Application No: 20/03626/DISC-2

Proposal: Discharge of Condition 8 (access vision splays) of 16/02446/F

Location: Heyford Park, Camp Road, Upper Heyford, Bicester, OX25 5HD

Transport Development Control

DETAILS: PHASE 9 ENGINEERING LAYOUT SHEET 3

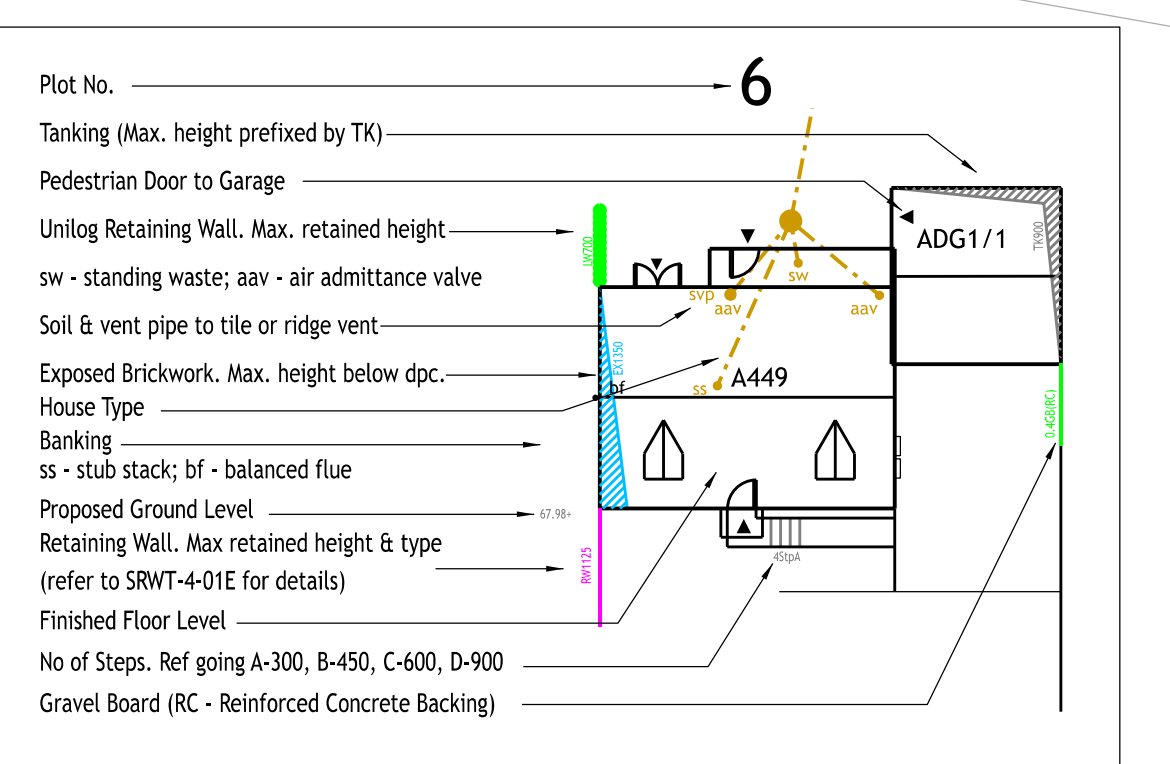
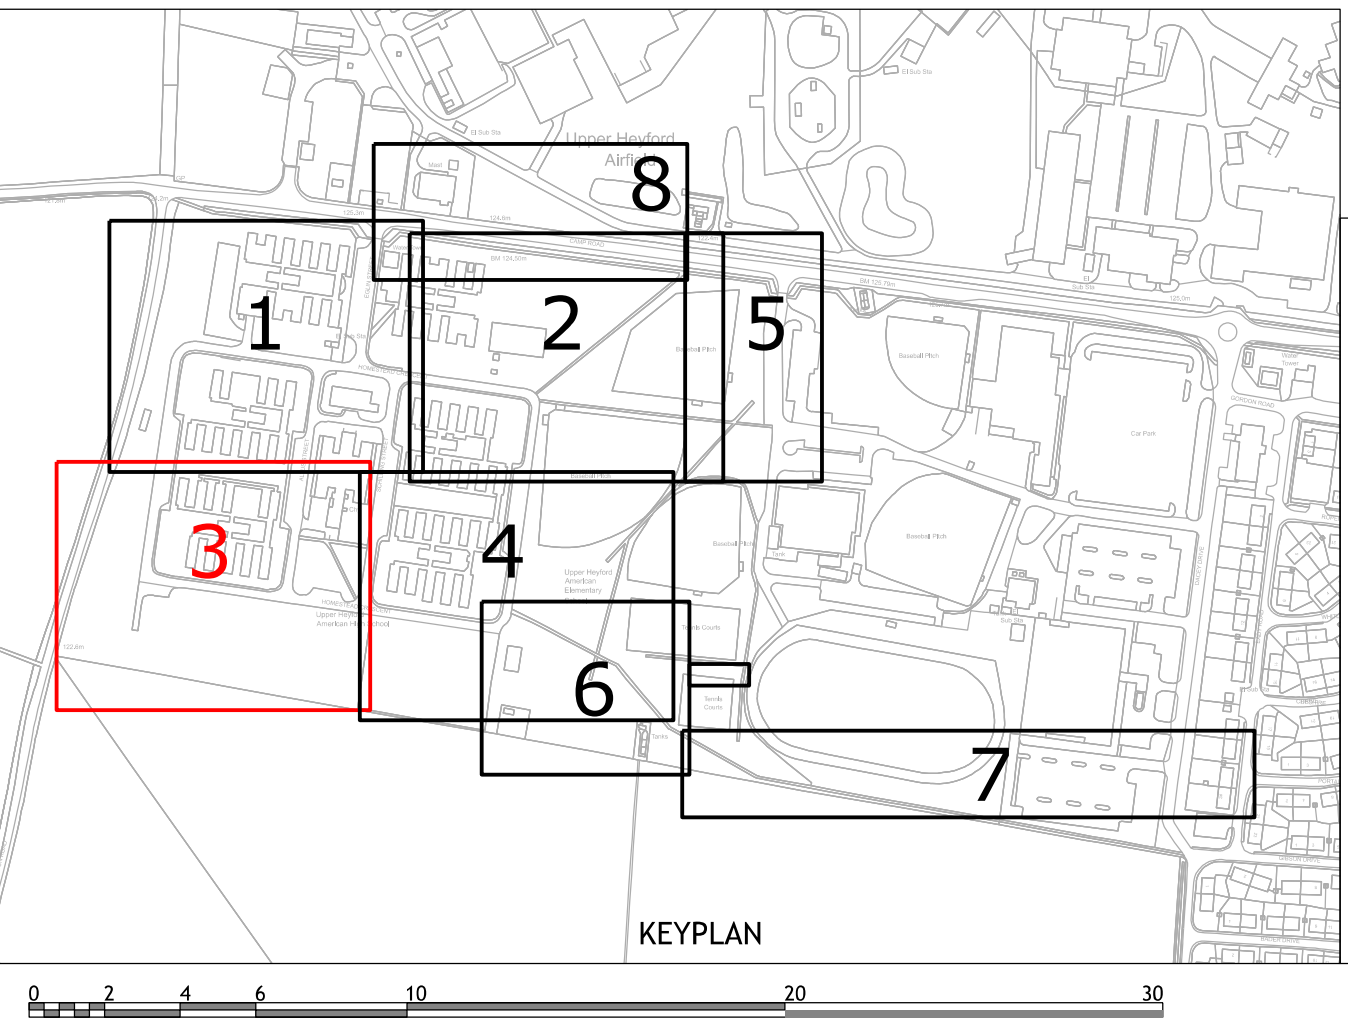
The drawings submitted with this planning application are difficult to read with visibility splays overlapping and annotation in some cases is barely legible. However, the County can confirm that this section of Camp Road is currently being audited under Section 278 and that proposed visibility splays are acceptable.
